Your Ref: OWPC24240
Our Ref: A/109/19/HH 15-08-2019
Please ask for:
Zac Denton

Demolition of existing garage and rear extension and erection of 2 storey side and rear extension with single storey wrap around extension to front and side.

Ty Gwyn The Avenals Angmering

PROPOSED ELEVATIONS AND BLOCK PLAN

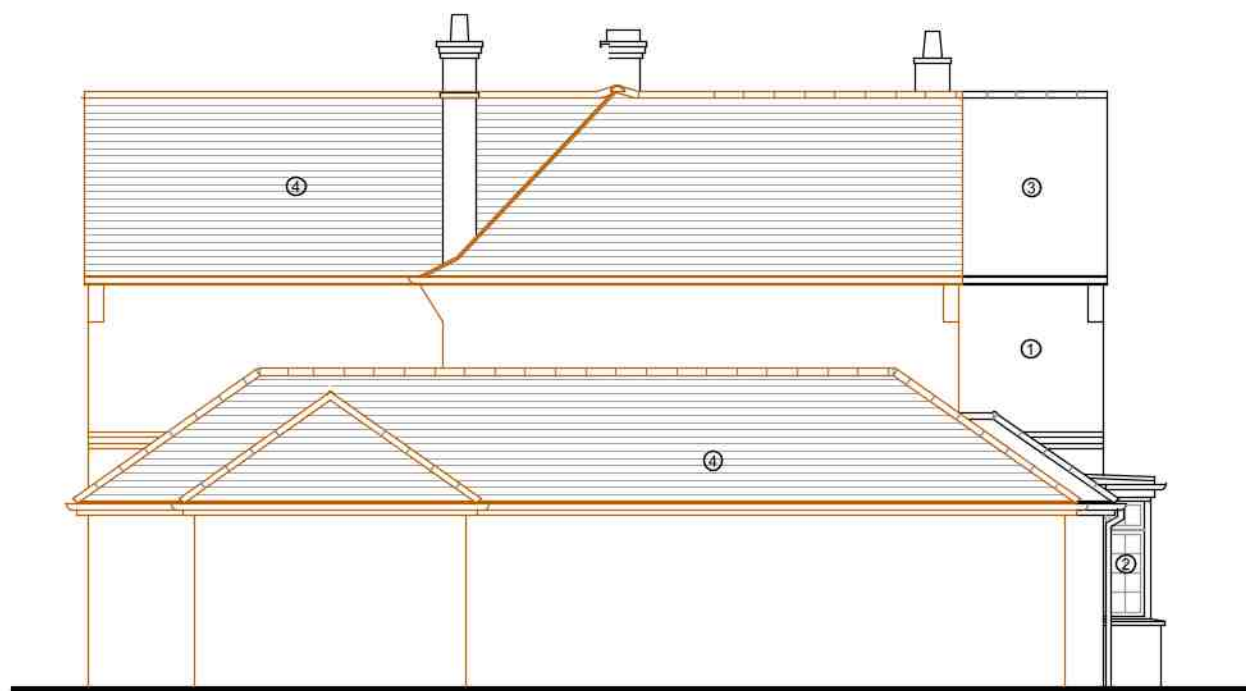
The plan is incorrect as the plot does not go down in a straight line on the west side. The protruding building from the boundary belongs to me. This makes the building closer to my boundary by 9ft. It also states in the planning notice that no trees will be removed, this is not true. To put the planned driveway in on these plans, an ancient apple tree will have to be removed.
